Gatwick Northern Runway Development Consent Order Application TR020005

Reigate & Banstead Borough Council 20044474

**Principle Areas of Disagreement Summary Statement (PADSS)
Version 3 Deadline 5 Submission Clean Version**

6th June 2024

Figure 1. Reptile Trapping Area A and Receptor Site

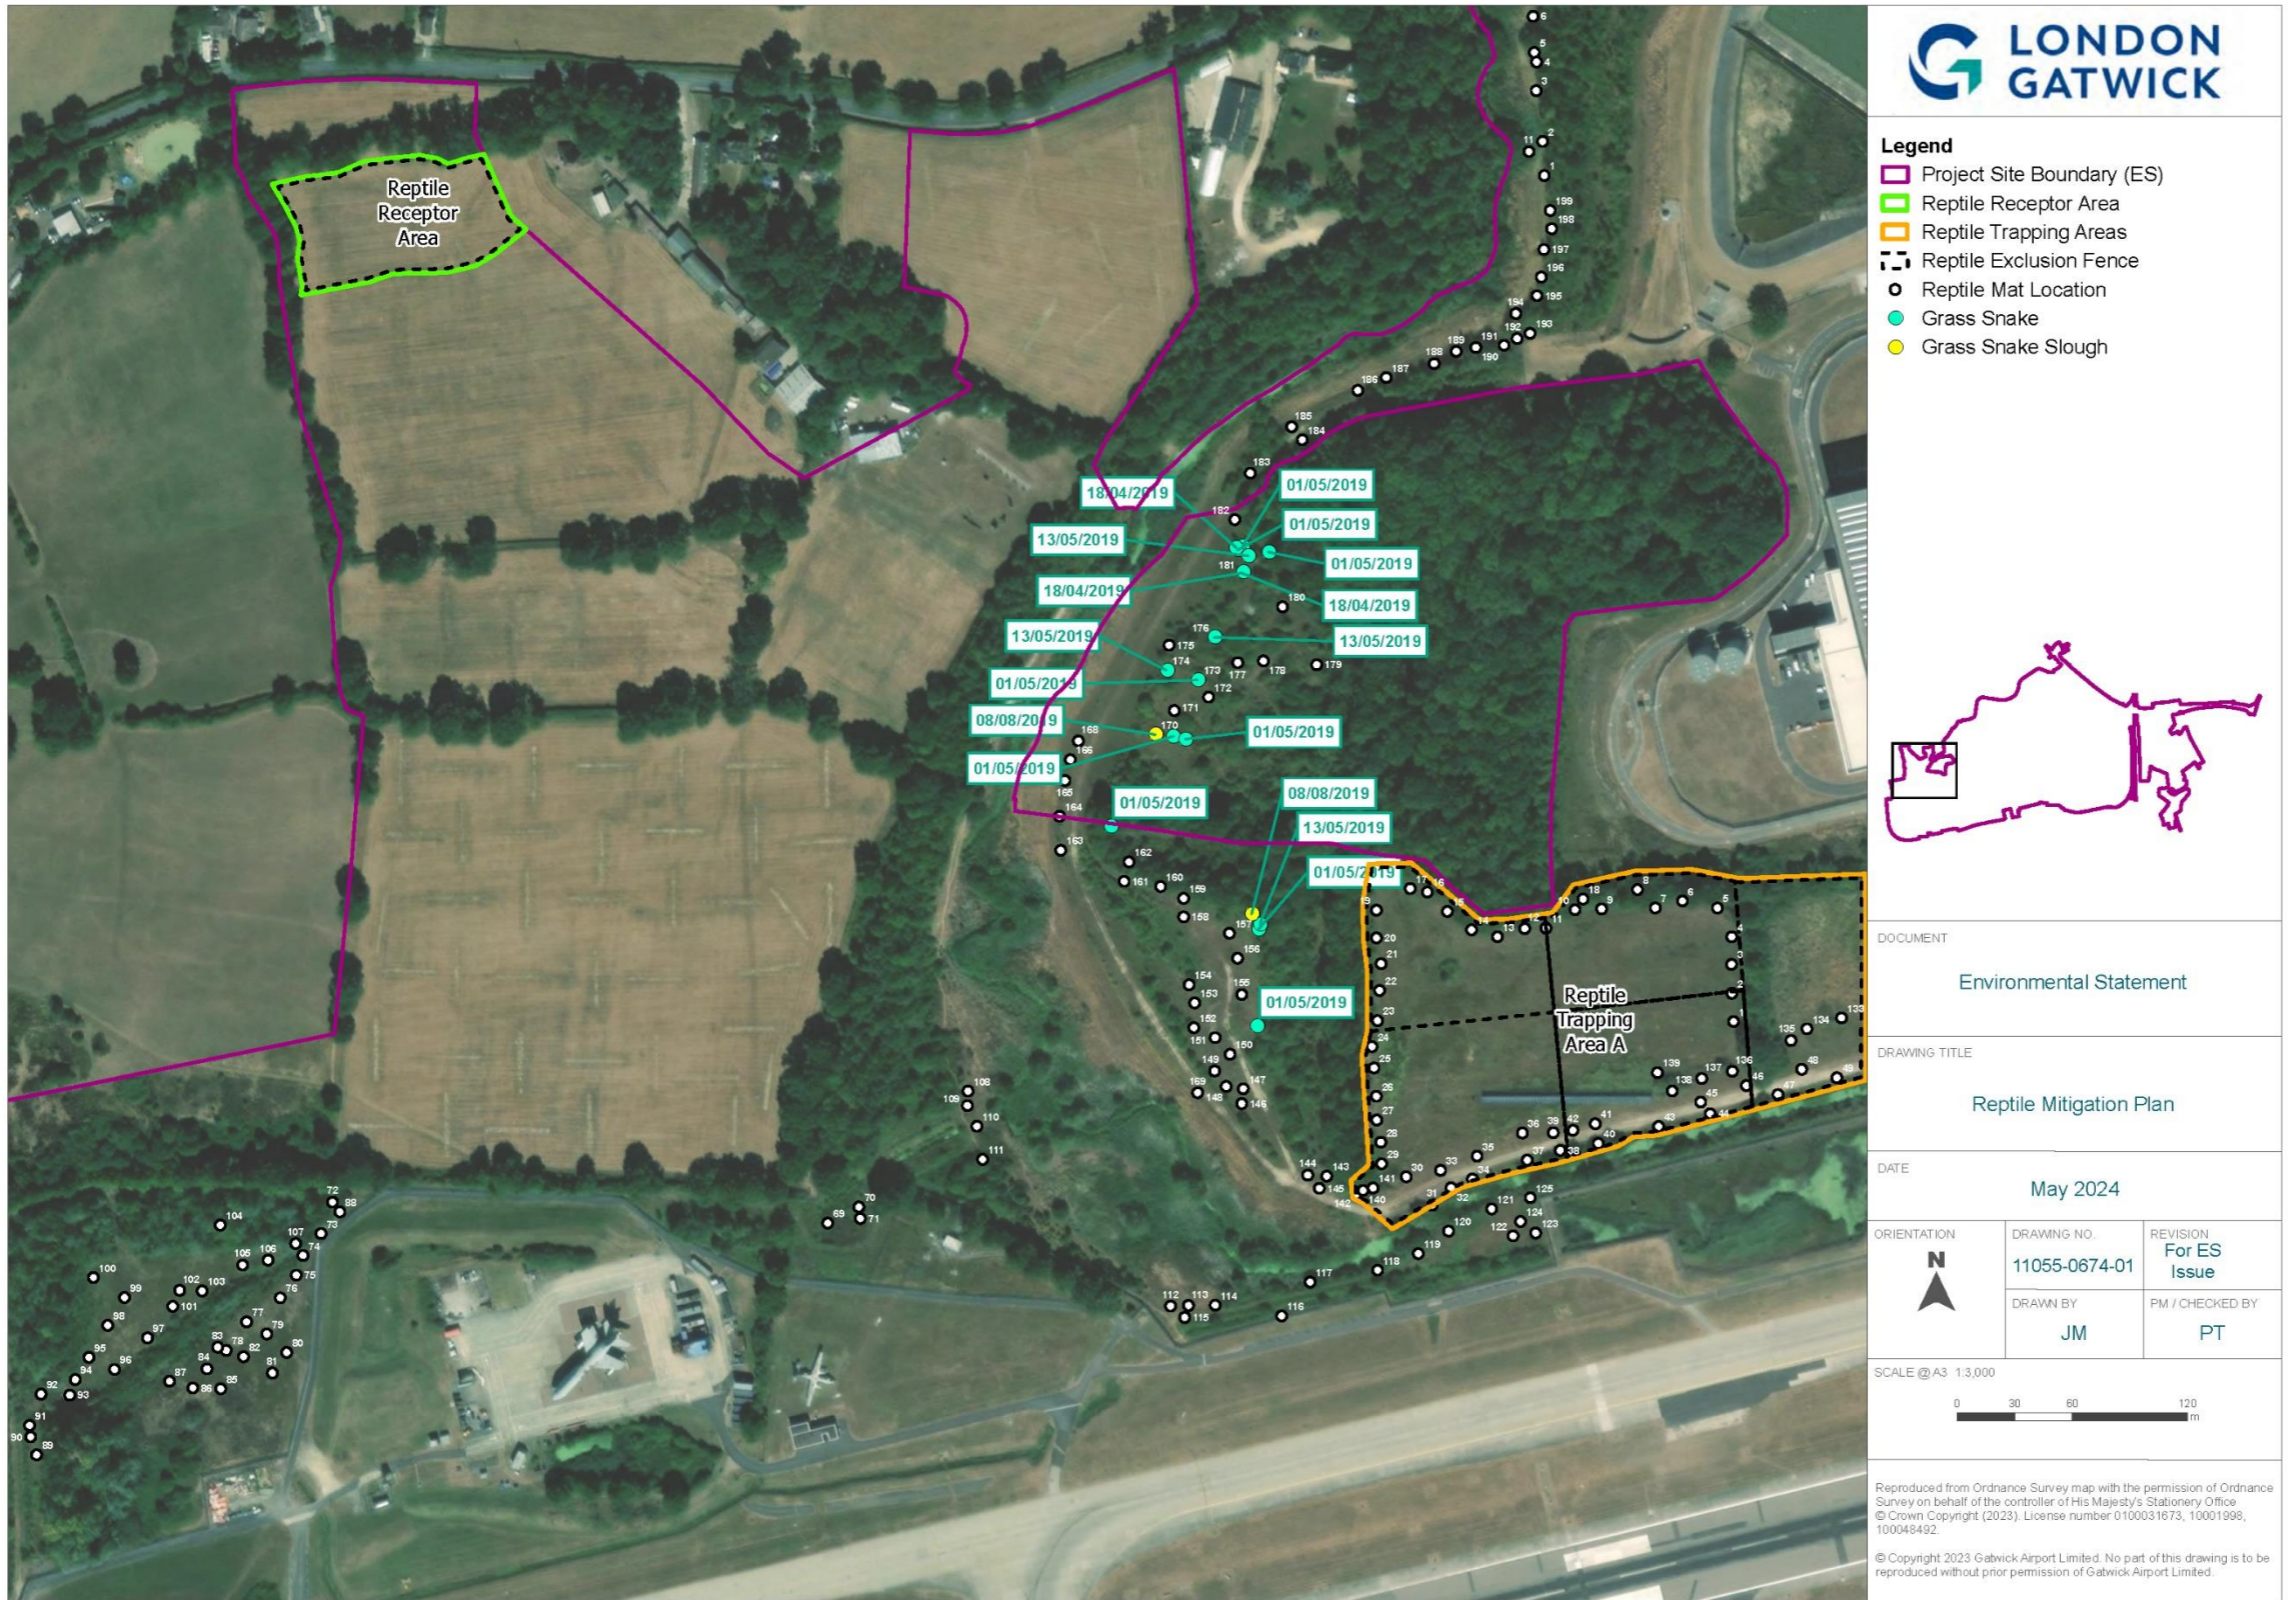
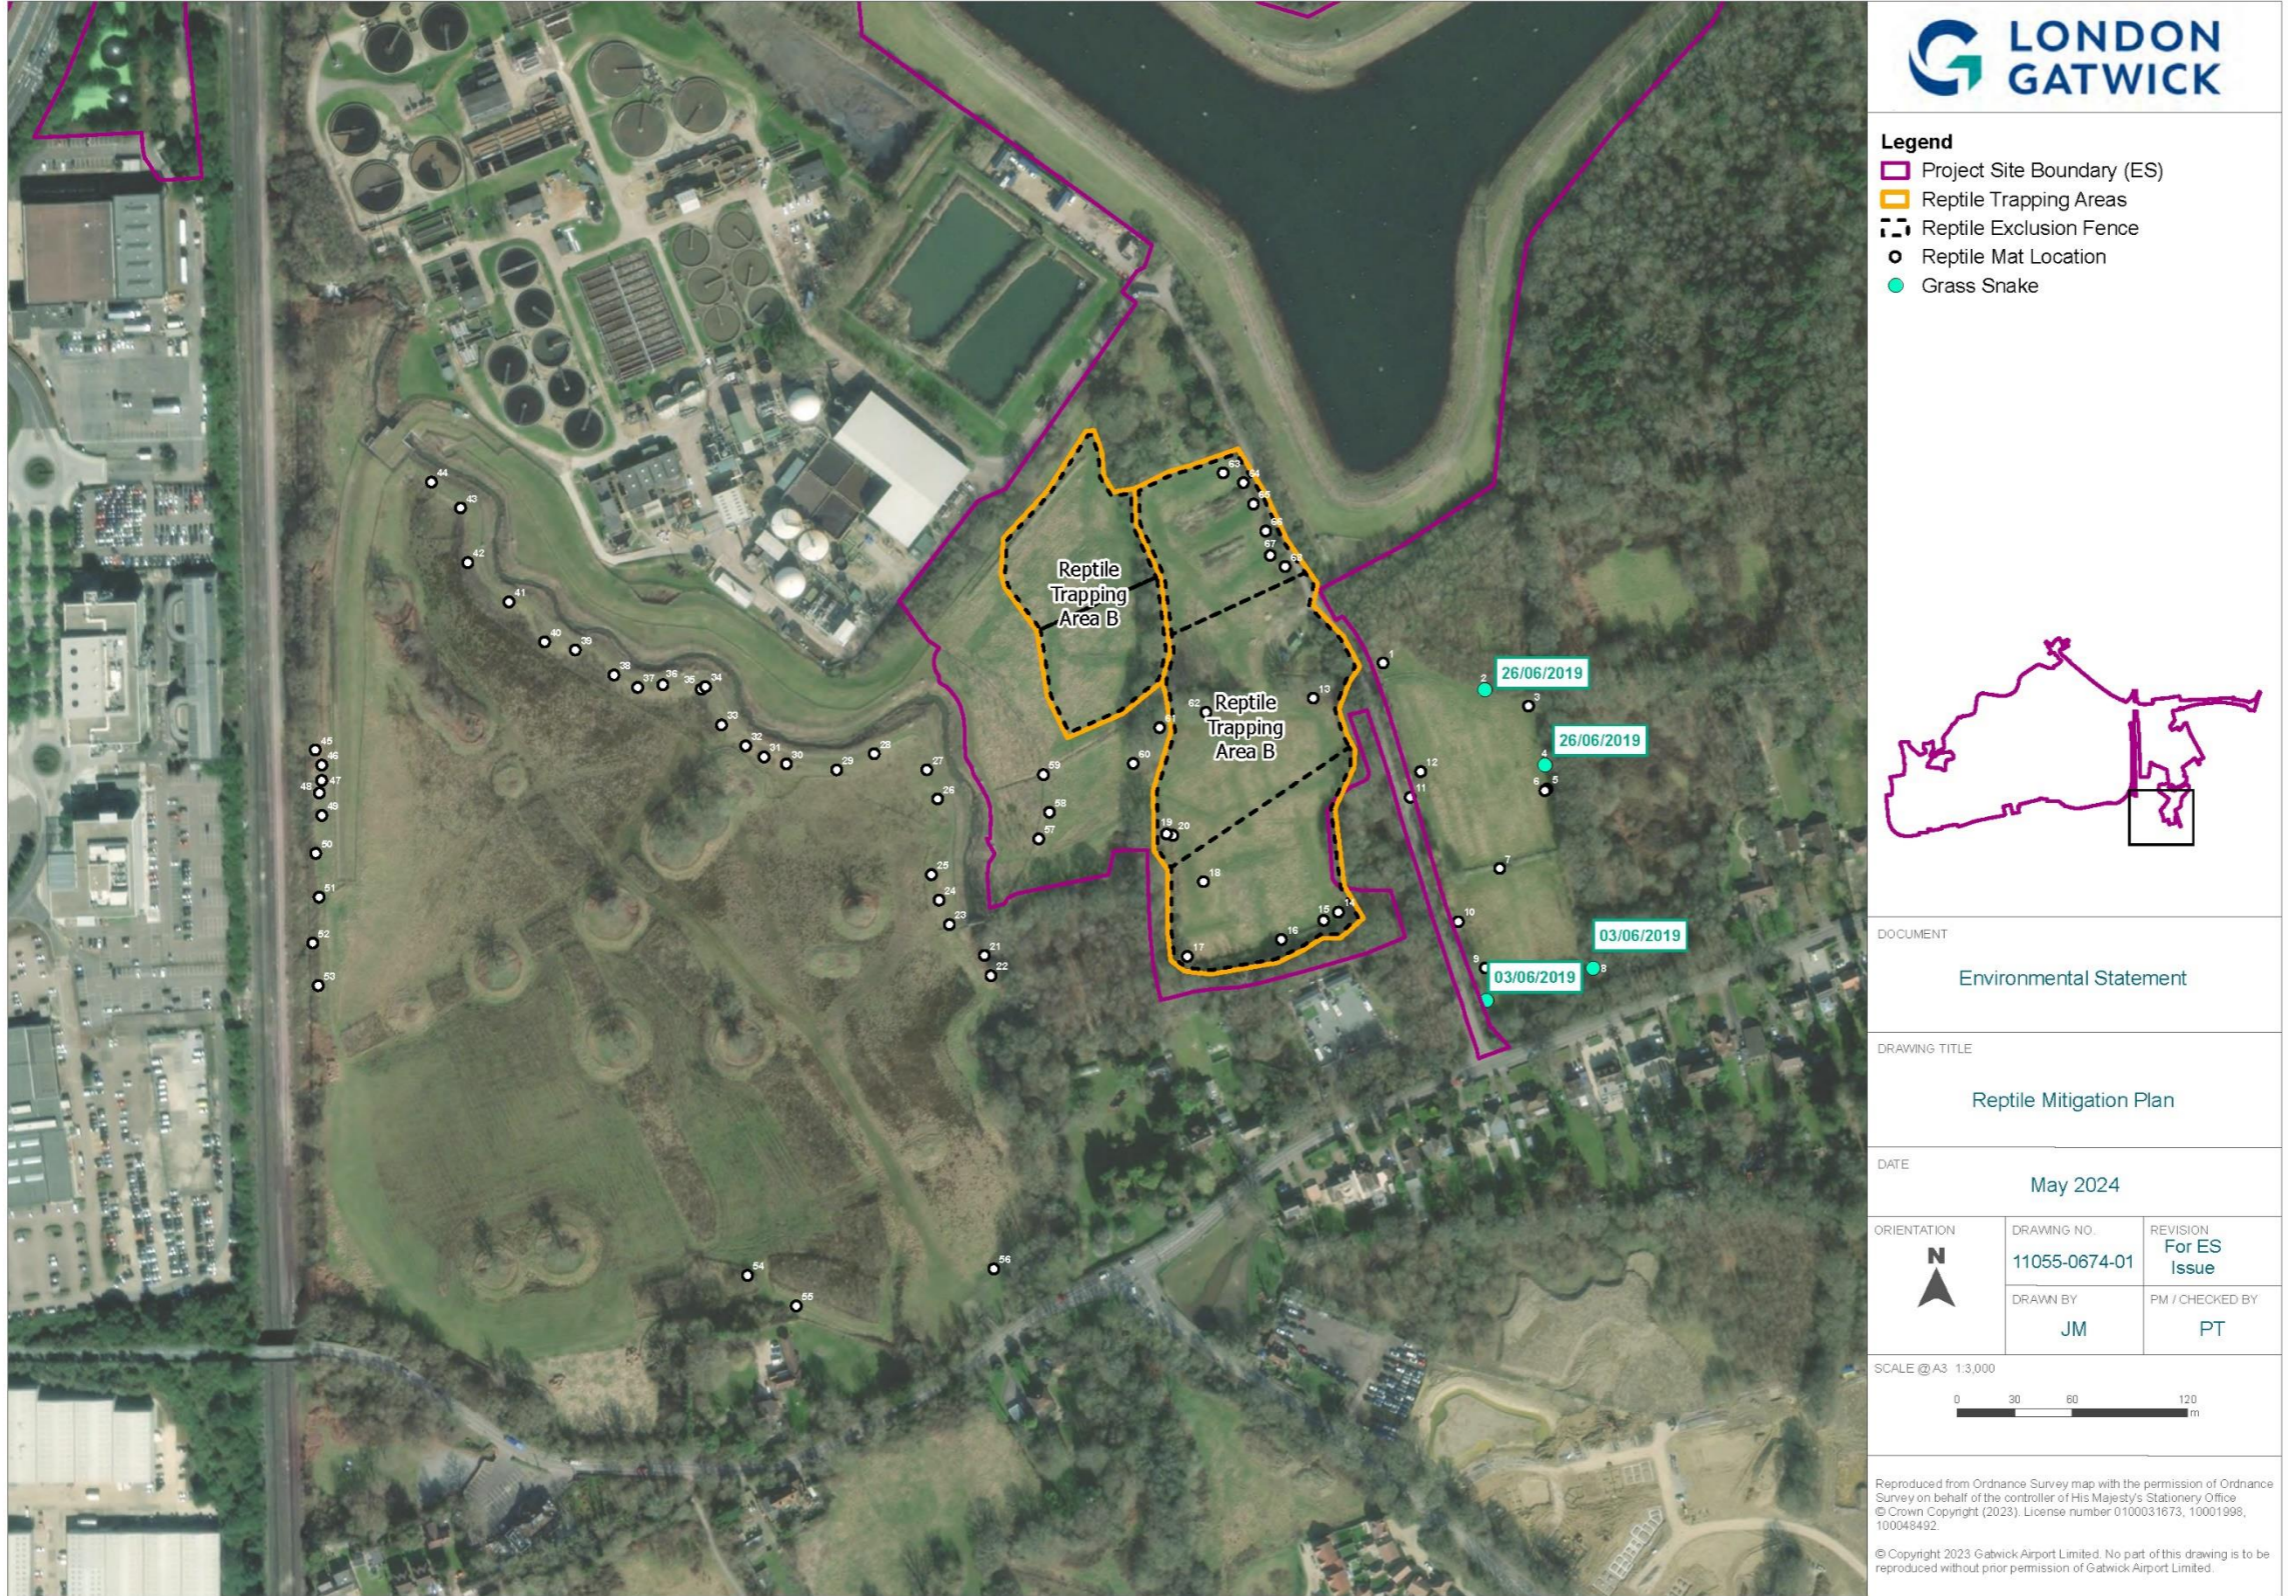
11.	<p>Lack of information on reptile and great crested newt (GCN) mitigation</p>	<p>The ecology chapter for the ES states that reptile and GCN mitigation will involve translocation to receptor sites and where relevant, European Protected Species Licences would be applied for post DCO consent. However, no detailed information is provided for the reptile and GCN mitigation strategy, for example:</p> <ul style="list-style-type: none"> • Where are the receptor sites? Reference is made to Longbridge Roundabout, Museum 	<p>Additional information has been provided in the Applicant's SoCG response. This should be included within the submission documentation. It remains unclear</p>	<p>Likely</p>

<p>fields and other mitigation areas but there is no detail as to which one of these has been chosen to be the receptor locations for reptiles and GCN.</p> <ul style="list-style-type: none"> • No methodology or timings information for the mitigation strategies. <p>Whilst it is appreciated that this is outline consent, an outline mitigation strategy is still required for reptiles and GCN.</p>	<p>whether residual impacts have been assessed appropriately without having an outline mitigation strategy in place.</p> <p>Updated position (Deadline 5): It is standard practice for an outline mitigation strategy to be submitted prior to planning approval. Whilst we appreciate the finer detail will come later, a high level overview is required so as to be satisfied that the 'favourable conservation status' of the population will be maintained. We will review the Deadline 5 submission.</p>
